Reference No:	<b>2025/62/90398/W</b>
Site Address:	202, Blacker Road, Edgerton, Huddersfield, HD2 2AA
Description:	Installation of roof lights, creation of dropped kerb and gated access and removal of external store and associated alterations and works (Listed Building within a Conservation Area).
Recommending Officer:	Edward Cheseldine

## **Officer Report – Planning Permission**

2025/90398 - 202, Blacker Road, Edgerton, Huddersfield, HD2 2AA

Title: Proposed Plans  
#

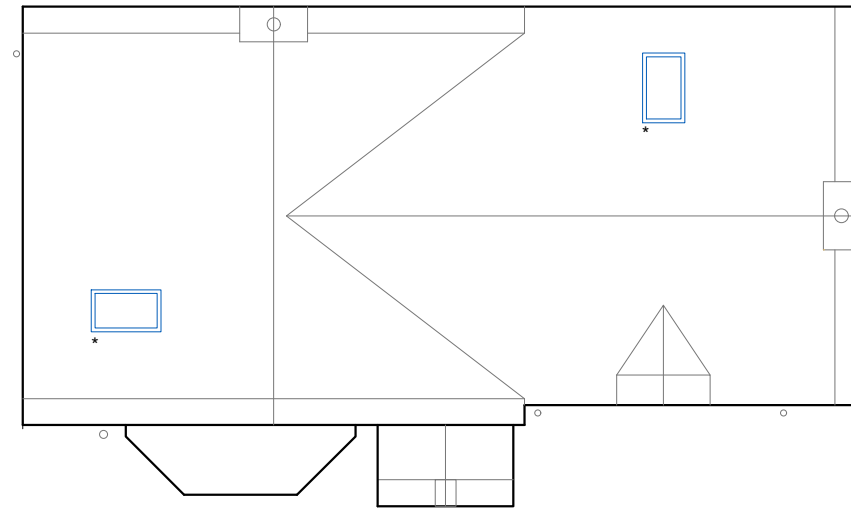
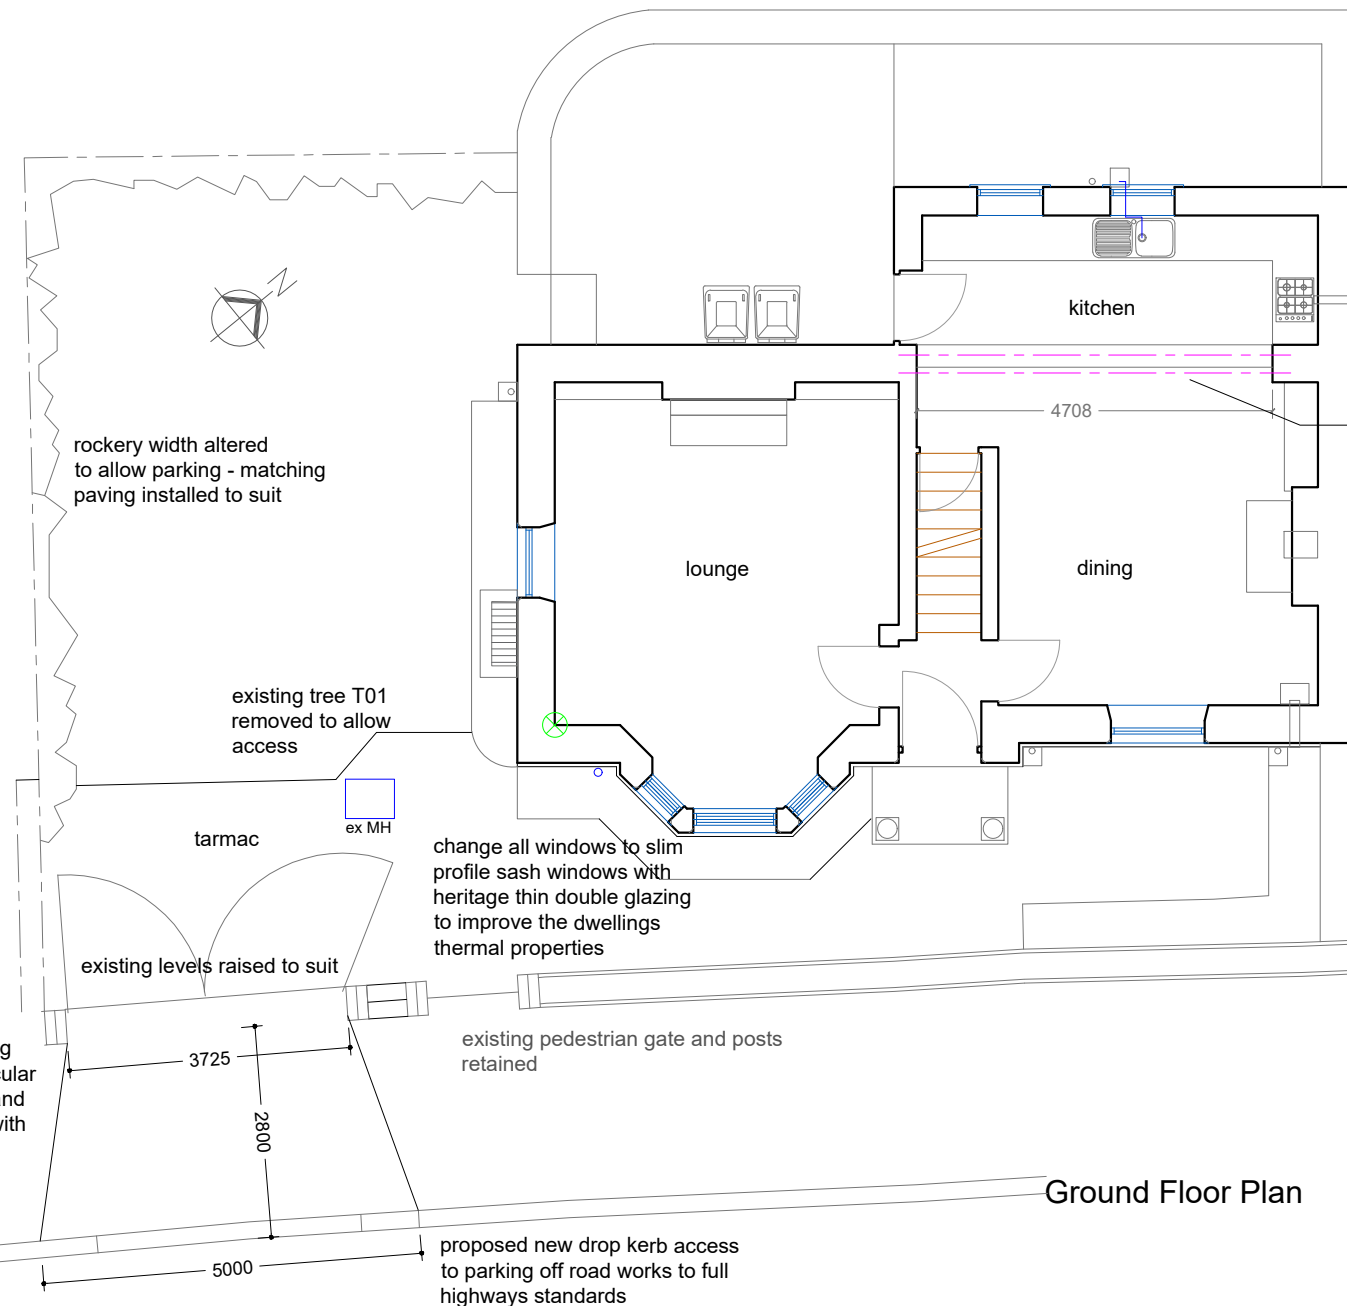
The applicant was asked to reduce the number of skylights on the side elevation to one window. Amended plans were received to include reducing the number of side elevation skylights.

KC Conservation & Design – No objection, requested window openings were reduced.

The amendments were received, satisfying the request of Conservation & Design.
